Further to our previous email responding to the conservation officers comments on Mill Cottage - I attach a detail of window shutters in flint walls. We are not yet able to confirm the stone paving spec for the external terrace and ask that this may be a condition prior to commencement of this part of work only along with the sample panel of new garden wall.

We have read through Martyn White's (Conservation officer) comments on Mill Cottage applications CM/38/19/PL and CM/39/19/L which are very useful and encouraging and we would like to confirm and respond as follows:

Mill Cottage:

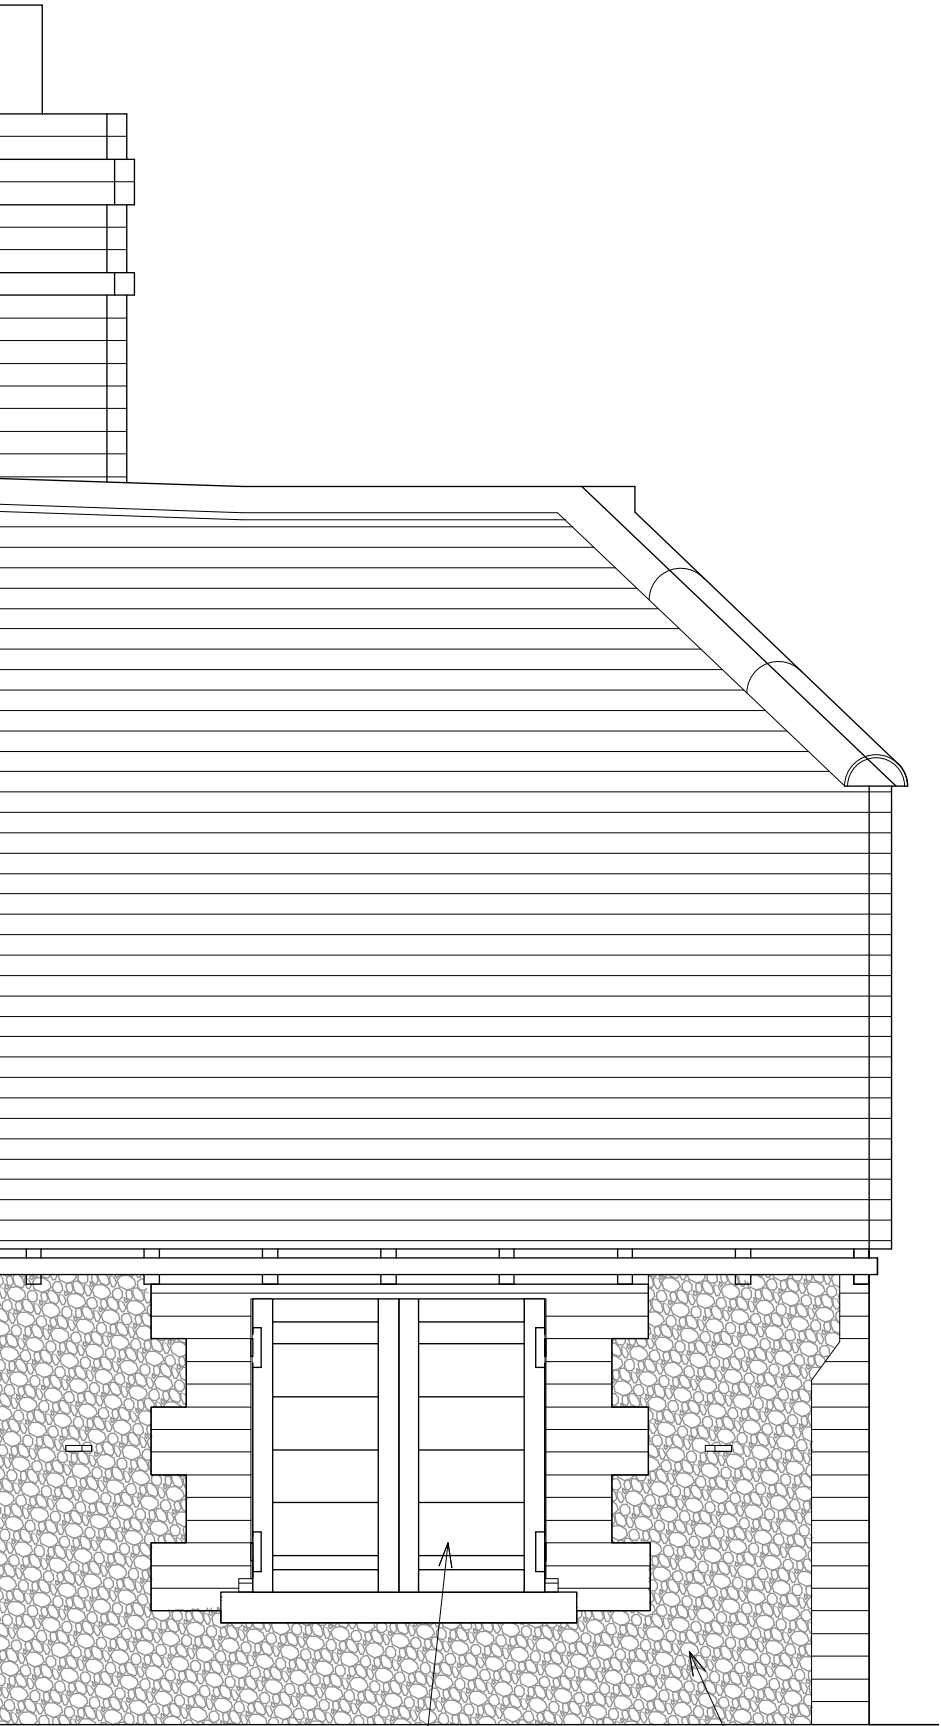
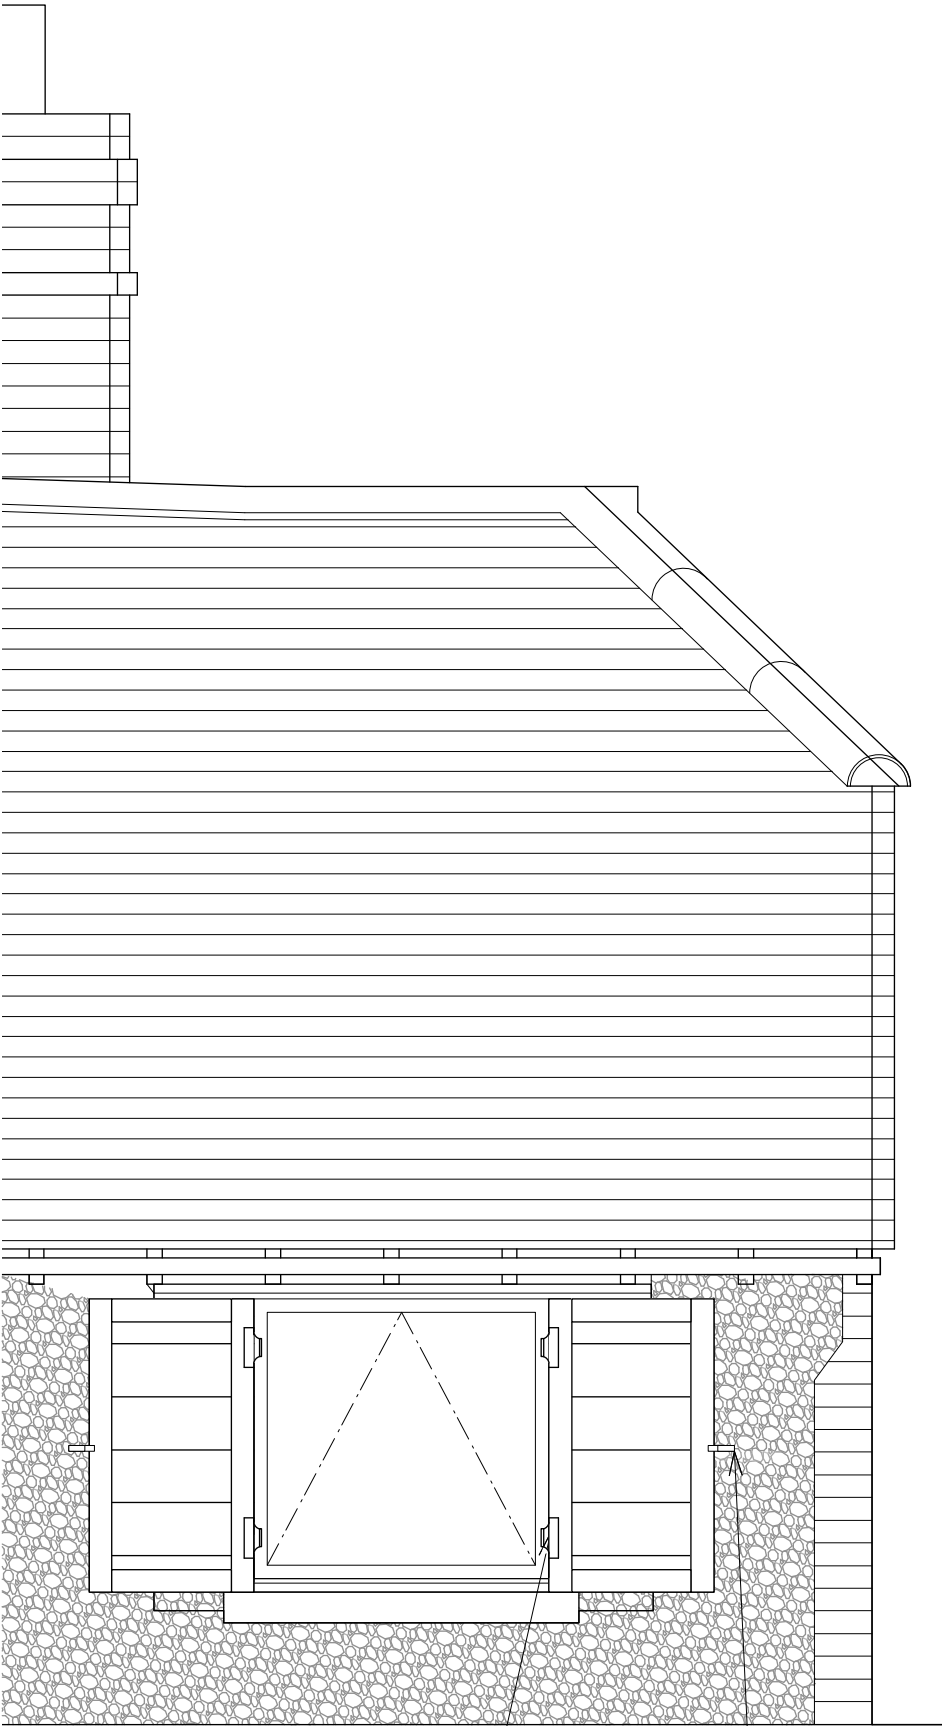
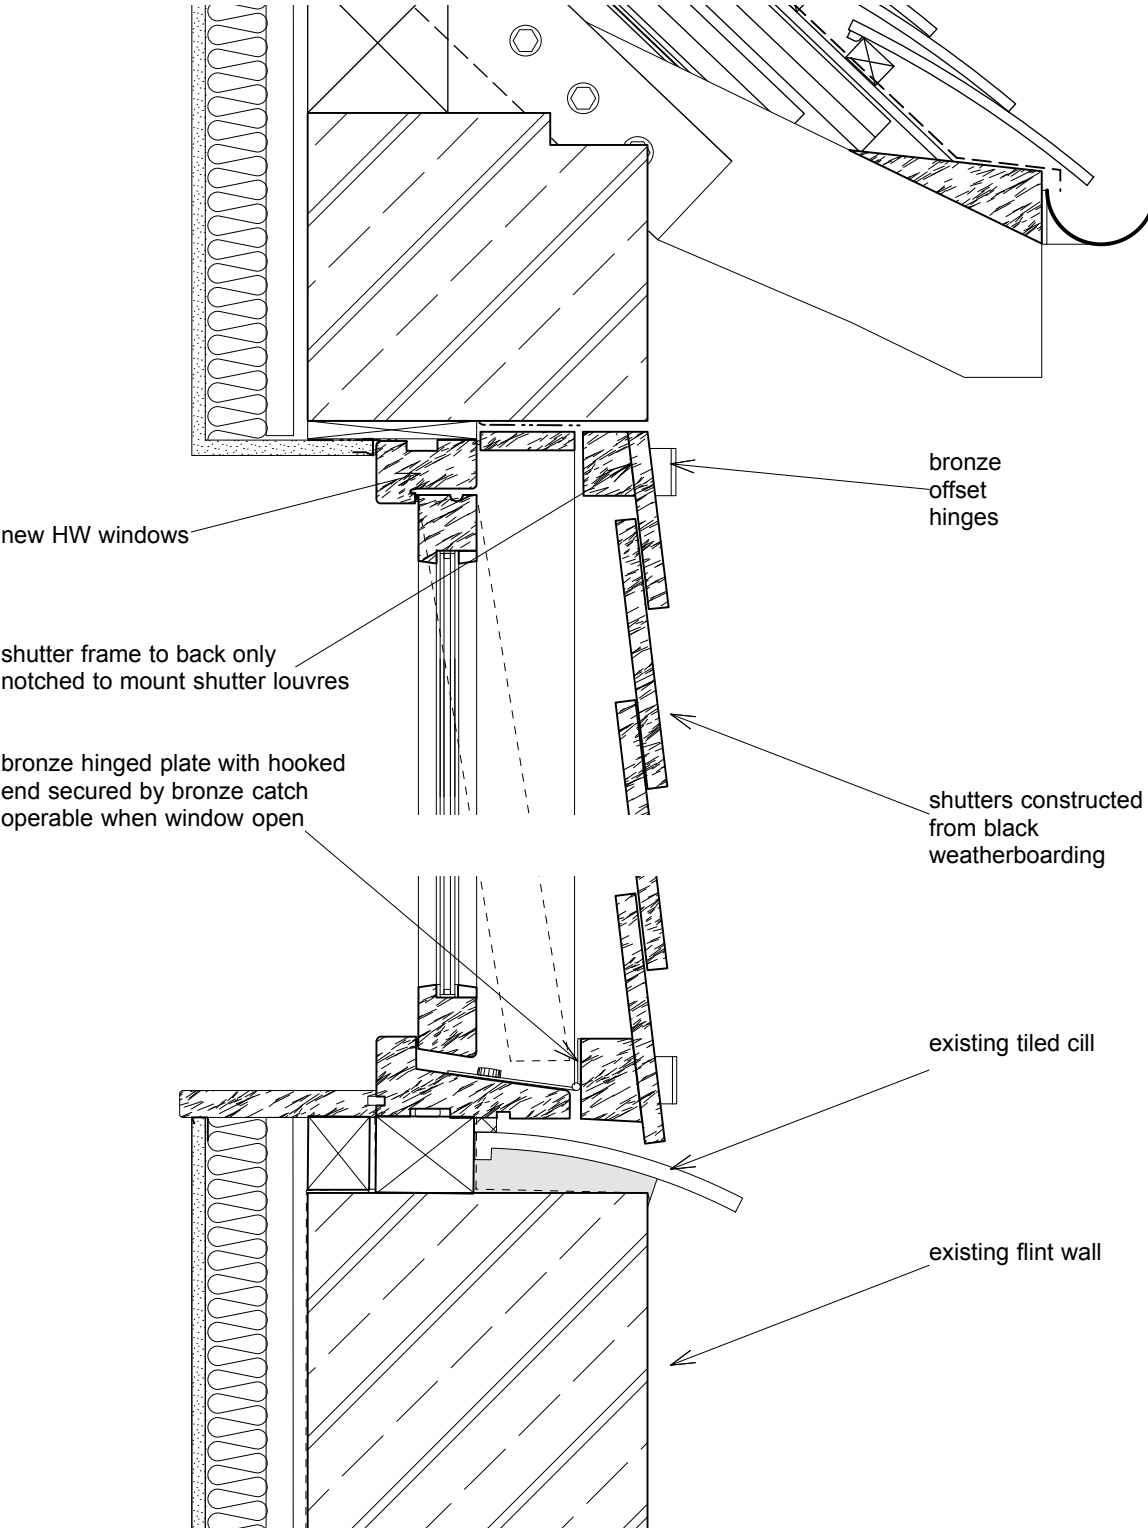
- Shutters detail to windows in flint walls
- Detail of stone paving specification on external terrace
-
